Application number: 2022/92799	
What is the application for?:	Erection of extensions, conversion of existing attached barn to living accommoda
Address of the site or building:	17, Town Gate, Upperthong, Holmfirth, HD9 3UX
Postcode:	HD9 3UX

User comments

17 Towngate Proposed Elevations

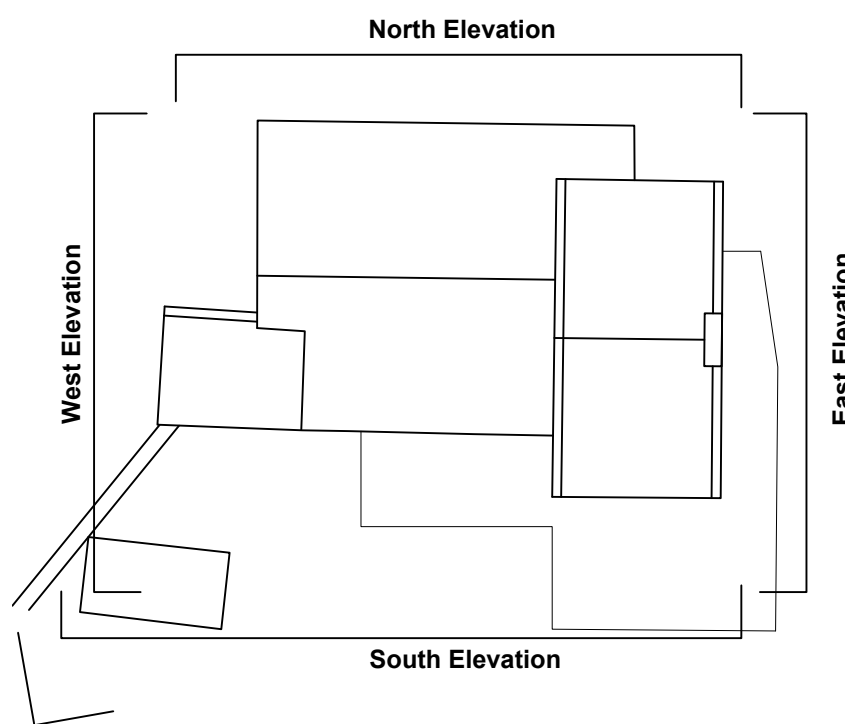
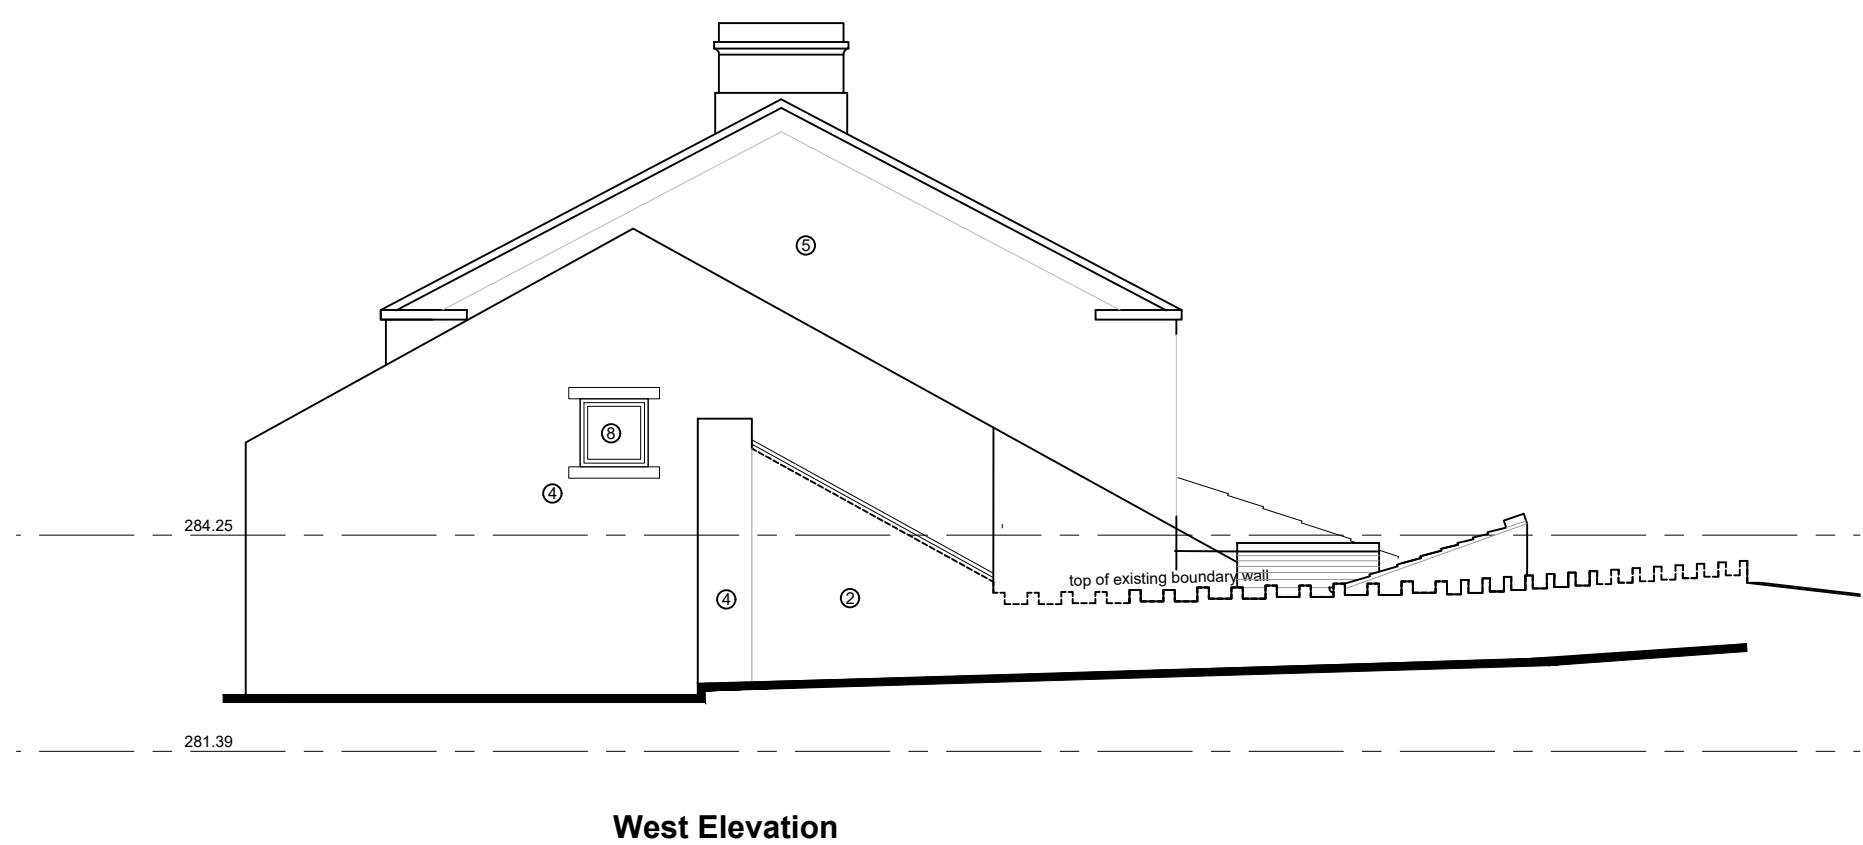
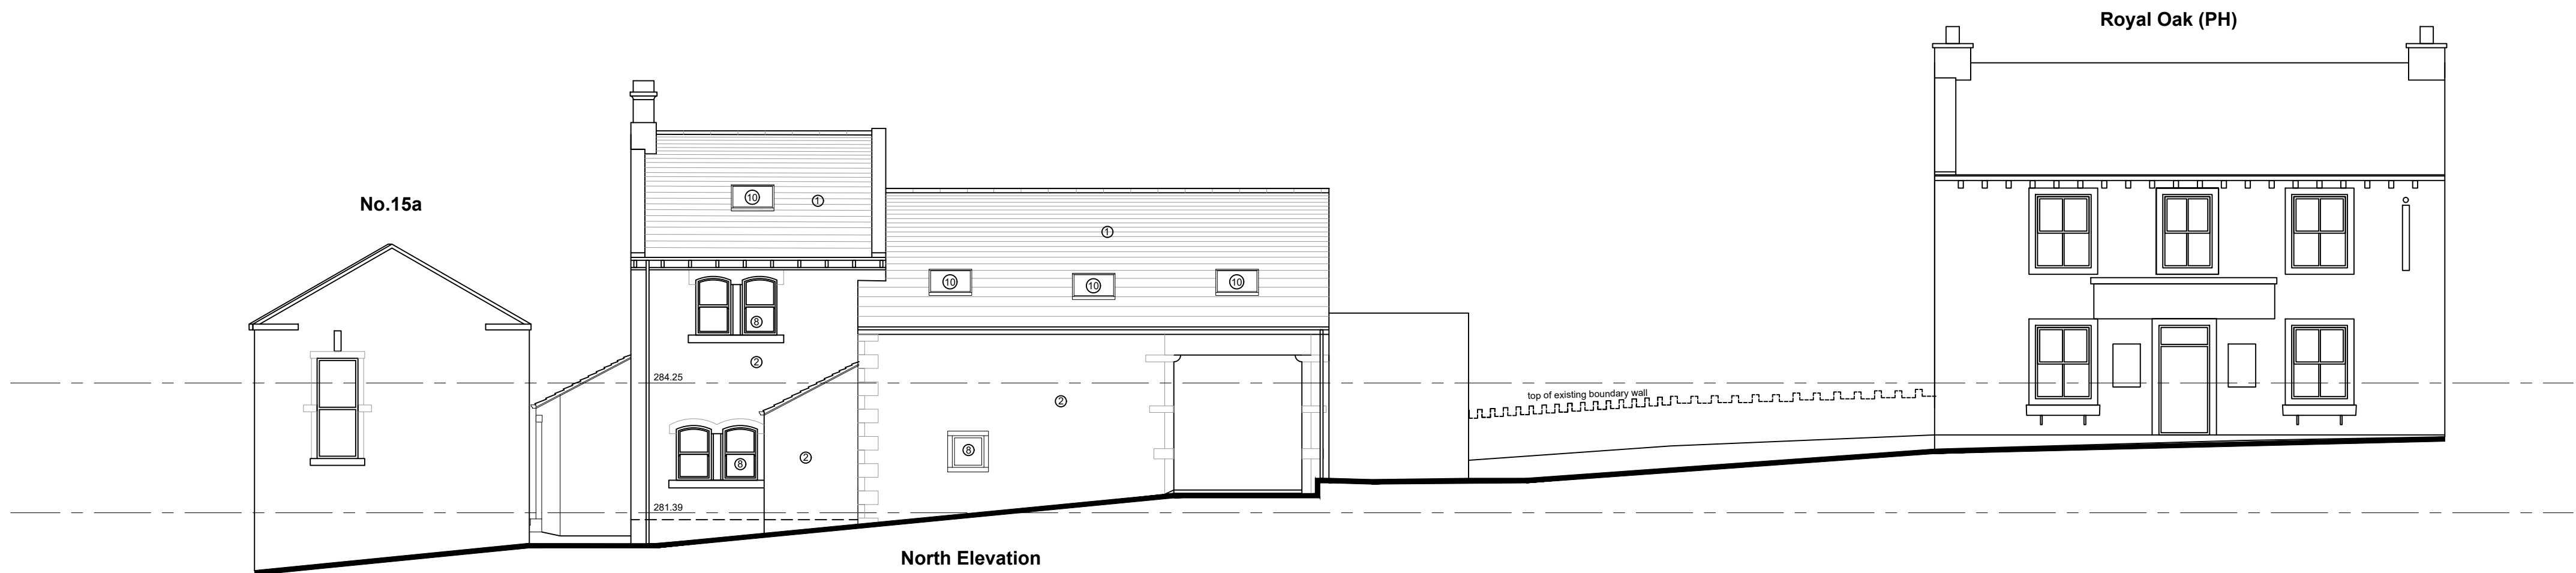
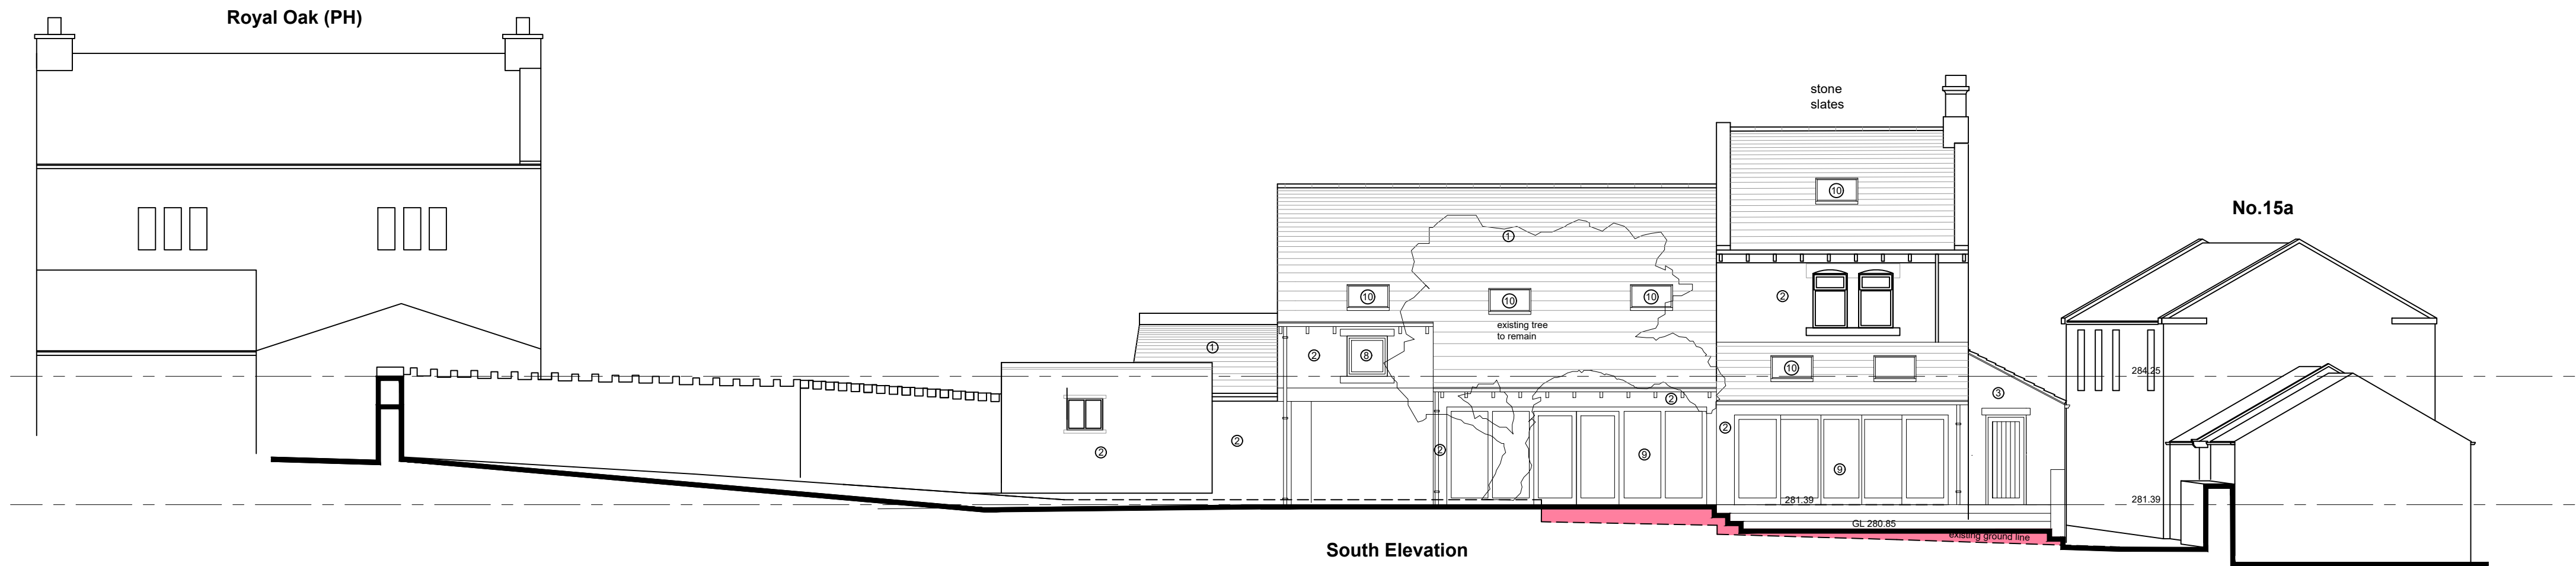
Type of comment: An objection	
Do you wish your comments to be published on the website anonymously?	Yes
The proposal to raise the boundary wall and construction of detached garage will impact and alter the streetscape of Towngate by removing the one of the last uninterrupted views from the road into the surrounding landscape. This will impact the character of the village and conservation area.
